Your Ref: OWPC4219
Our Ref: AB/115/14/OUT 17-09-2014
Please ask for:
Mr D Sullivan

Outline application with some matters reserved for 2No. 3 bed semi detached houses
12 & 14 Canada Road Arundel

Thank you for your internet representation made on 6th November 2014 which has been recorded as '**an objection**' with the comments as follows:

Drg Title: SITE PLAN		Drg No: 14/1950/S01
Client:	Location:	Rev: A
MR SCODFREY	12-14 CANADA ROAD	Scale: 1:200 (A3)
	ARUNDEL	Drawn by: JSW

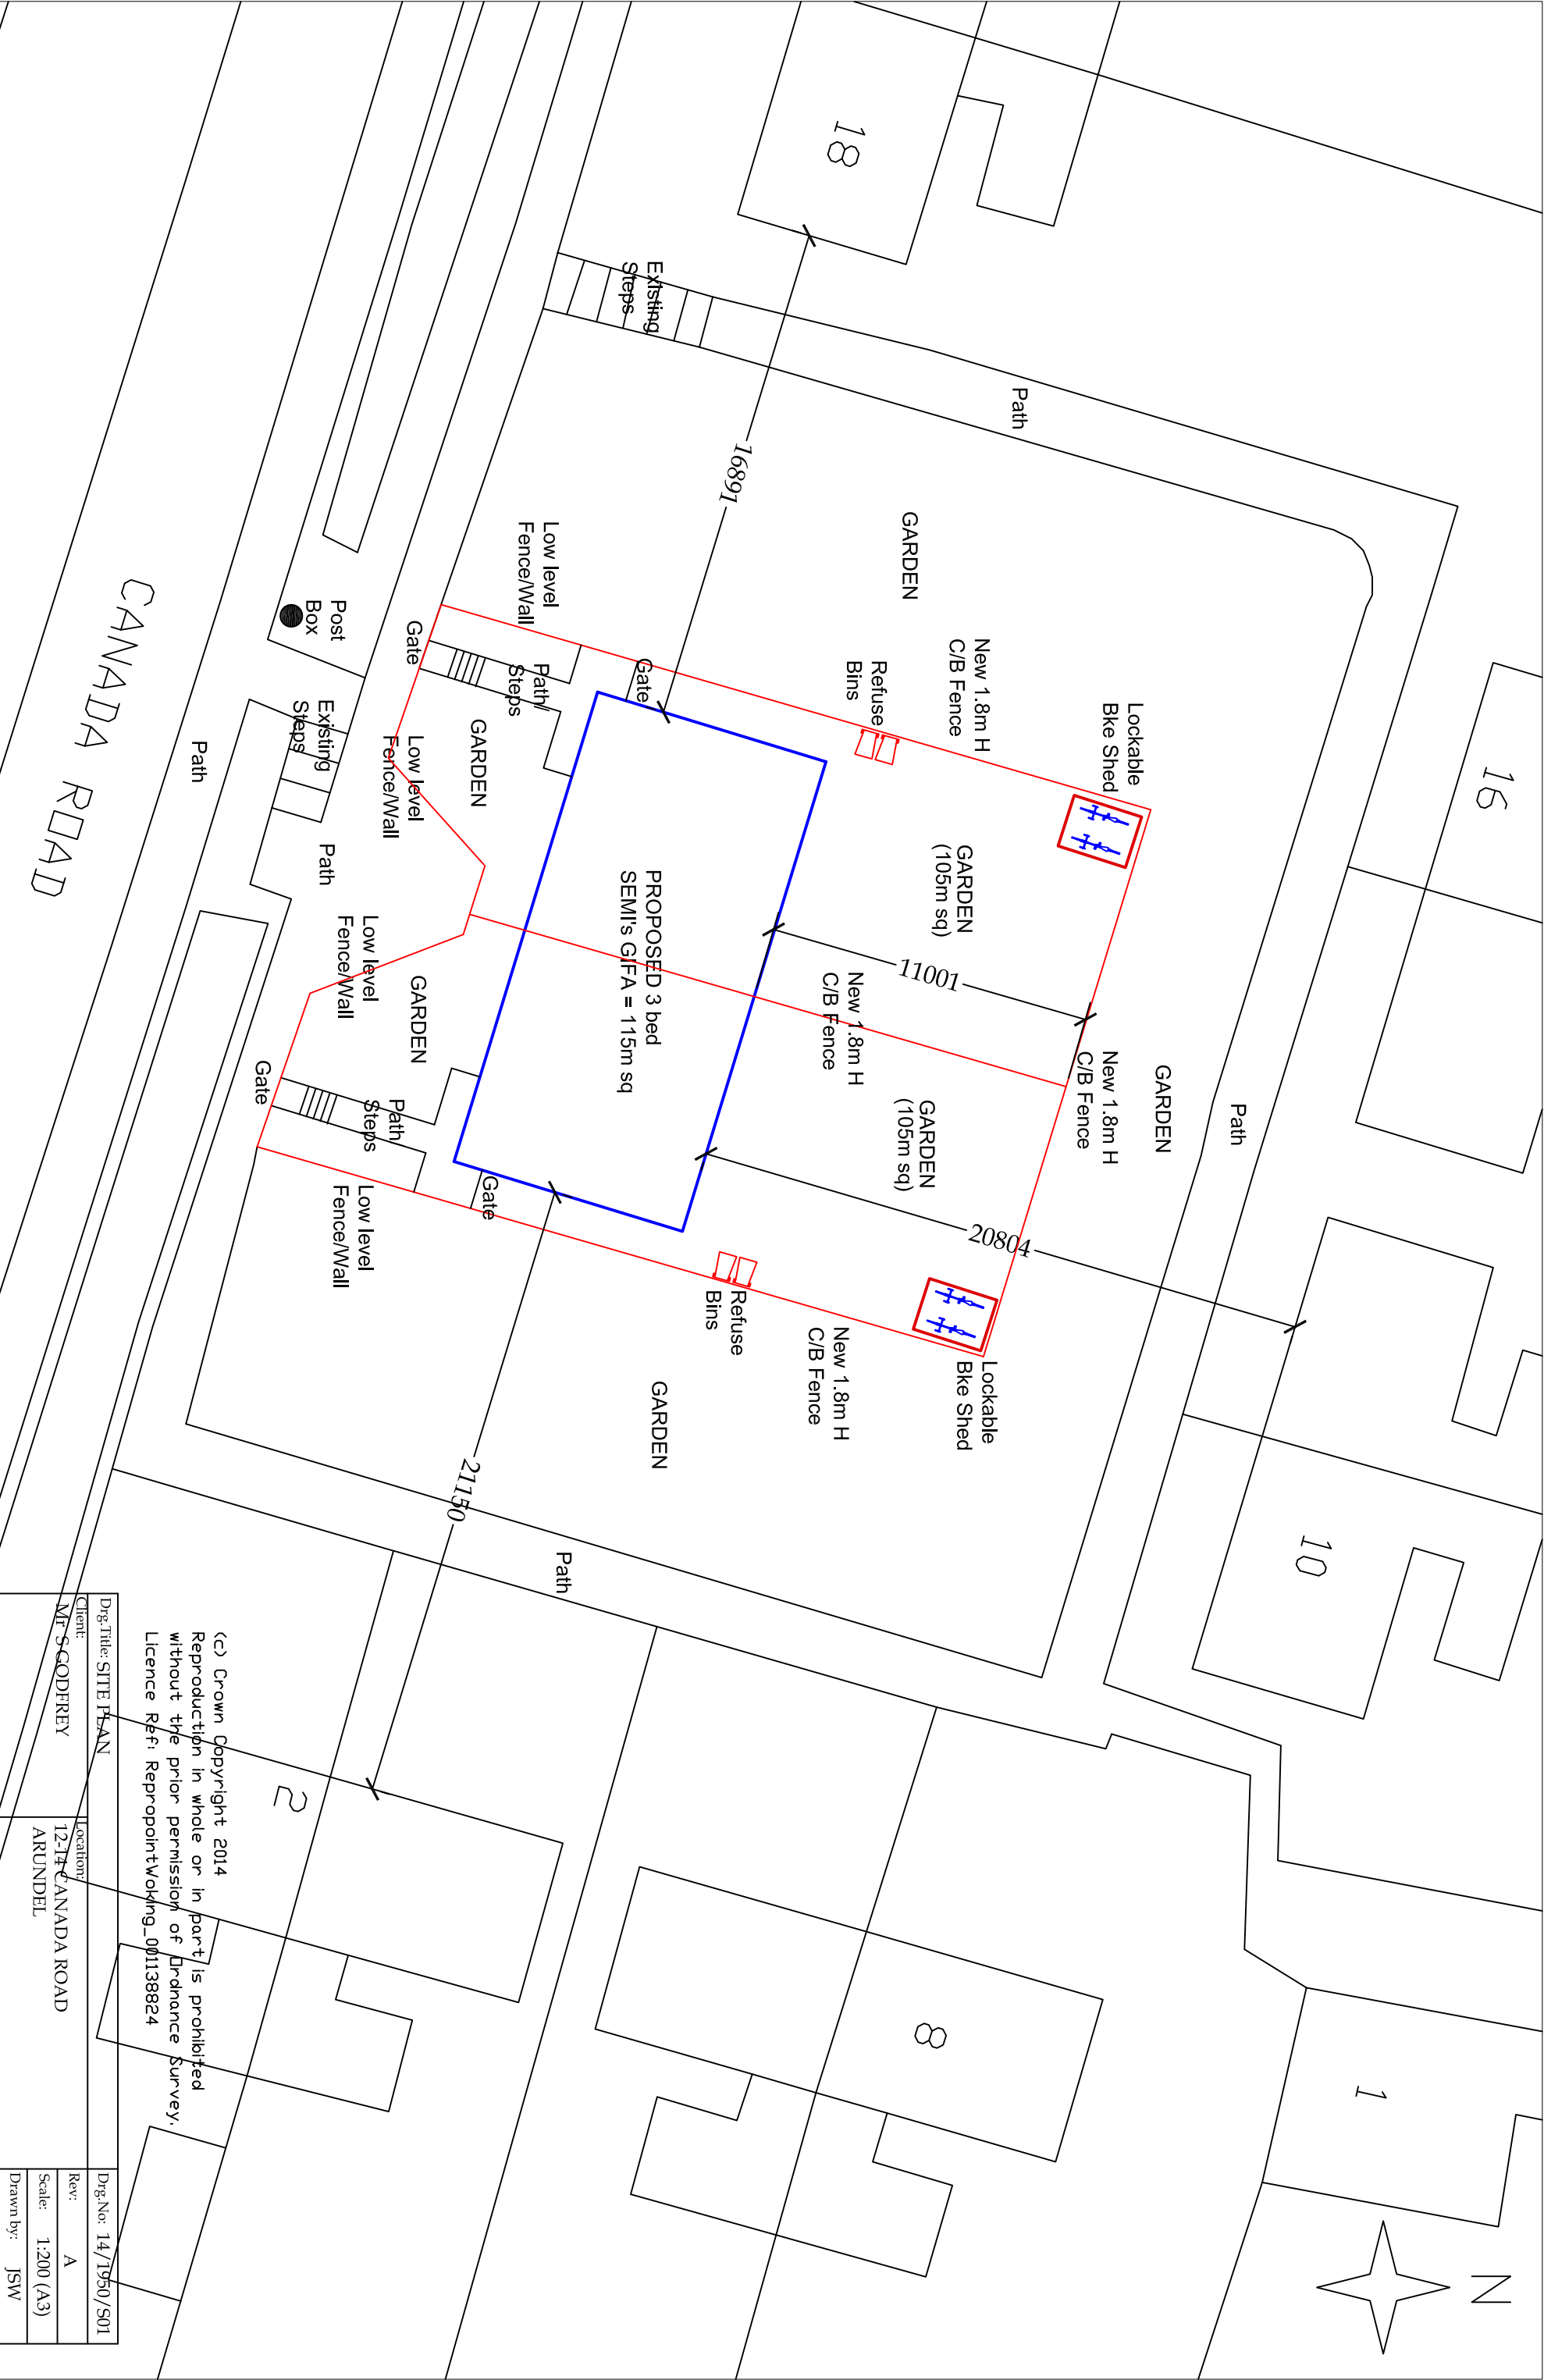
I object to the application because I do not think they have considered the impact on the parking in this area. It is already difficult to park here in the evenings and weekends. The removal of the off road parking, as a result of this application, will push parking to the limits without the addition of new homes and their vehicles. Any additional houses would mean you cannot rely on parking in this part of the road and there are no suitable alternatives. I feel that their parking survey does not reflect the actual situation, and notice it was completed in the summer holidays when people were away. I feel this survey should be reassessed.

There are a large number of young adults who are of driving age, and others approaching that age in the houses near the proposed site, and these should be considered alongside the parking survey, this will further add to the problem. Each new house could add 2 or more cars so they should incorporate their own parking spaces in the plan in line with government guidelines.

I also do not think it is appropriate to build a house in front of another house when it is not in keeping with the existing neighbourhood design.
